**KIRKLEES METROPOLITAN COUNCIL
INVESTMENT & REGENERATION SERVICE**

DELEGATED DECISION TO DETERMINE PLANNING APPLICATIONS

Reference No:	2025/62/90089/W
Site Address:	11b, Back Green, Outlane, Huddersfield, HD3 3YT
Description:	Erection of single storey side extension with first floor in roof space, erection of dormer windows and alterations to garage/flat to form one dwelling including associated parking areas, creation of associated amenity spaces and works
Recommending Officer:	Joanna Rednall

DECISION – REFUSED

PROPOSED SOUTH WEST ELEVATION 1:50

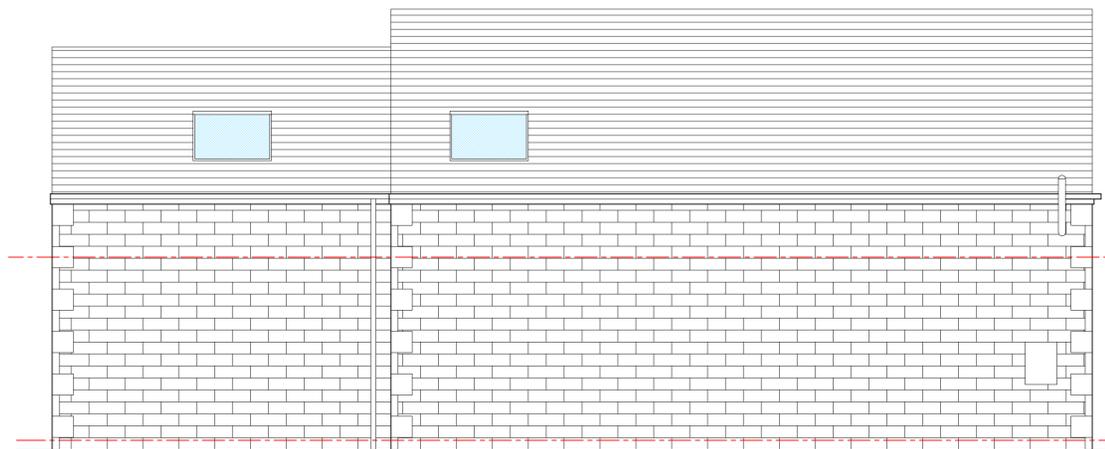
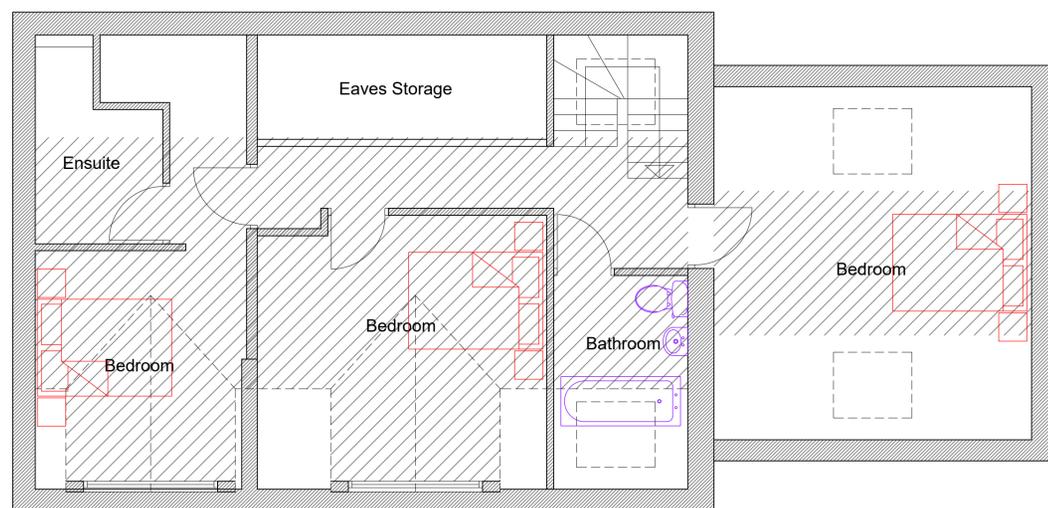
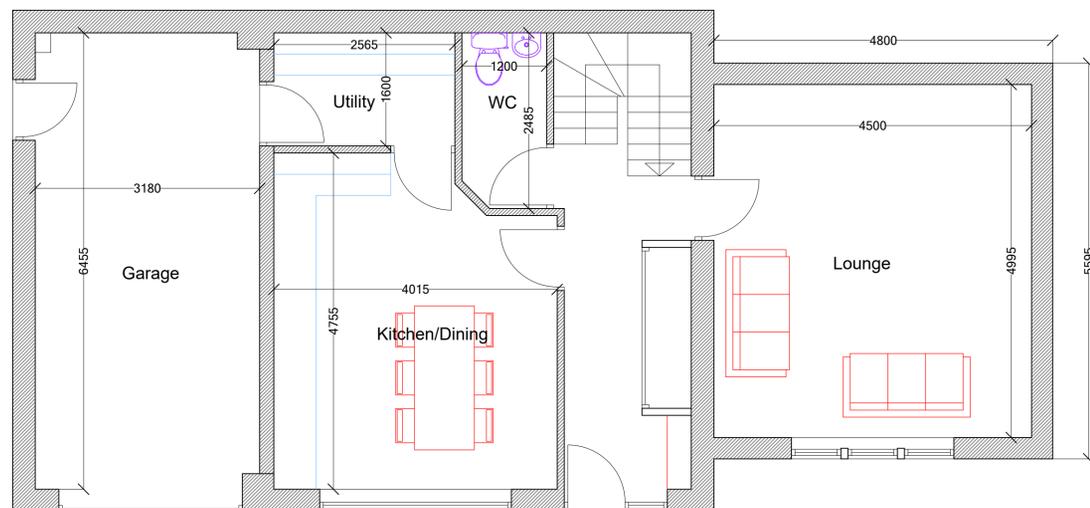
The proposed side extension projects 4.8 metres from the side of 11b, with a depth of 5.5 metres. The extension features a pitched roof, set lower than the host building, and would be finished with materials that match the original structure. The roof design mirrors that of the existing building, and officers consider the extension's design would harmonize well with the existing form and linear alignment of the building. The extension is set back from the original building line, and its relatively modest scale ensures it remains subservient to the original structure. The proposed fenestration will be residential in style, consistent with both the host building and surrounding development. The first floor would be served by two rooflights, one to the front and one to the rear. These would be in keeping with existing openings on 11b and are considered to appropriately harmonise with the application building.

However, despite the above considerations, officers consider the principle of the side extension would be unacceptable in this case. This is because the development as a whole would constitute inappropriate development in the Green Belt in terms of extending the residential curtilage and encroachment into the countryside, contrary to the aims of paragraph 143c of the NPPF.

Twin dormers are proposed to the front elevation of 11b, Back Green. The dormers are measure 2.4 metres in width, 2.8 metres in depth, 1 metre in eave height, and 2 metres in ridge height. The dormers are designed with pitched roofs to match the existing roof form of 11b, Back Green and are modest in scale, ensuring that the majority of the front roof slope remains intact and to avoid over-dominating the front elevation of 11b, Back Green. They are set above the eaves and do not project above the ridge of 11b, and their modest scale prevents the proposed dormers from overwhelming the front roof slope or creating an unbalanced, top-heavy appearance. The dormers are aligned with the existing ground floor openings and would appear consistent with its overall design of 11b. Should the application be recommended for approval, it would be necessary to impose a condition requiring the dormers to be constructed using materials that match the existing roof.

In terms of overlooking, the development would introduce new dormer openings facing 11A, where no openings currently exist. These dormer windows would serve habitable rooms (bedrooms). According to the Council's SPD, to maintain a reasonable level of privacy for the occupiers of both dwellings, a minimum separation distance of 12 metres is recommended between windows of habitable rooms and non-habitable rooms, and at least 21 metres between facing windows of habitable rooms. It has been assessed that a separation distance of approximately 25 metres will be maintained between these neighbours and 11B, in line with the SPD's recommendations, therefore due to the separation distance, the development is considered to have an acceptable impact on the privacy of the occupiers of 11A and 11.

PROPOSED SITE LAYOUT 1:200

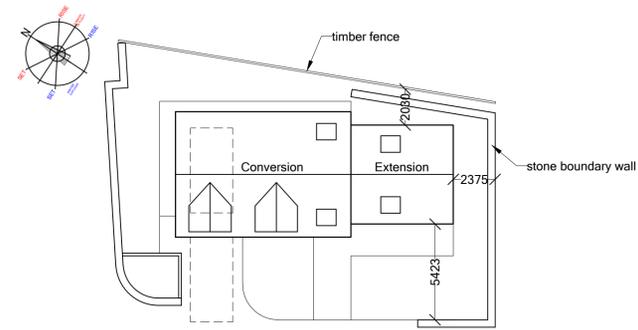
In this case the proposal would see encroachment into the Green Belt conflicting with one of the purposes of including land within the Green Belt, the extent of the encroachment goes beyond the established building line whereby built form of residential properties is up to the Green Belt boundary rather than within it.

The encroachment of built form as a result of hardstanding areas and extensions proposed as part of this application has a harmful impact eroding the openness of the Green Belt through the introduction of urban features in a part of the site which was previously free from development and contributed to the wider openness of this part of the Green Belt. The proposal is therefore considered to have a visually harmful impact in this regard in relation to the openness of the Green Belt and is also considered to have a harmful impact by reason of inappropriateness given it relates to inappropriate development within the Green Belt.

The submitted site layout plan indicates that an area of hardstanding will be retained at the front of 11b, with amenity spaces surrounding the dwelling. The amenity space will remain unchanged, and while one parking space will be removed, one garage will be retained. These alterations are relatively modest and would not negatively impact the visual amenity of 11b, Back Green, or the wider amenity of Back Green.
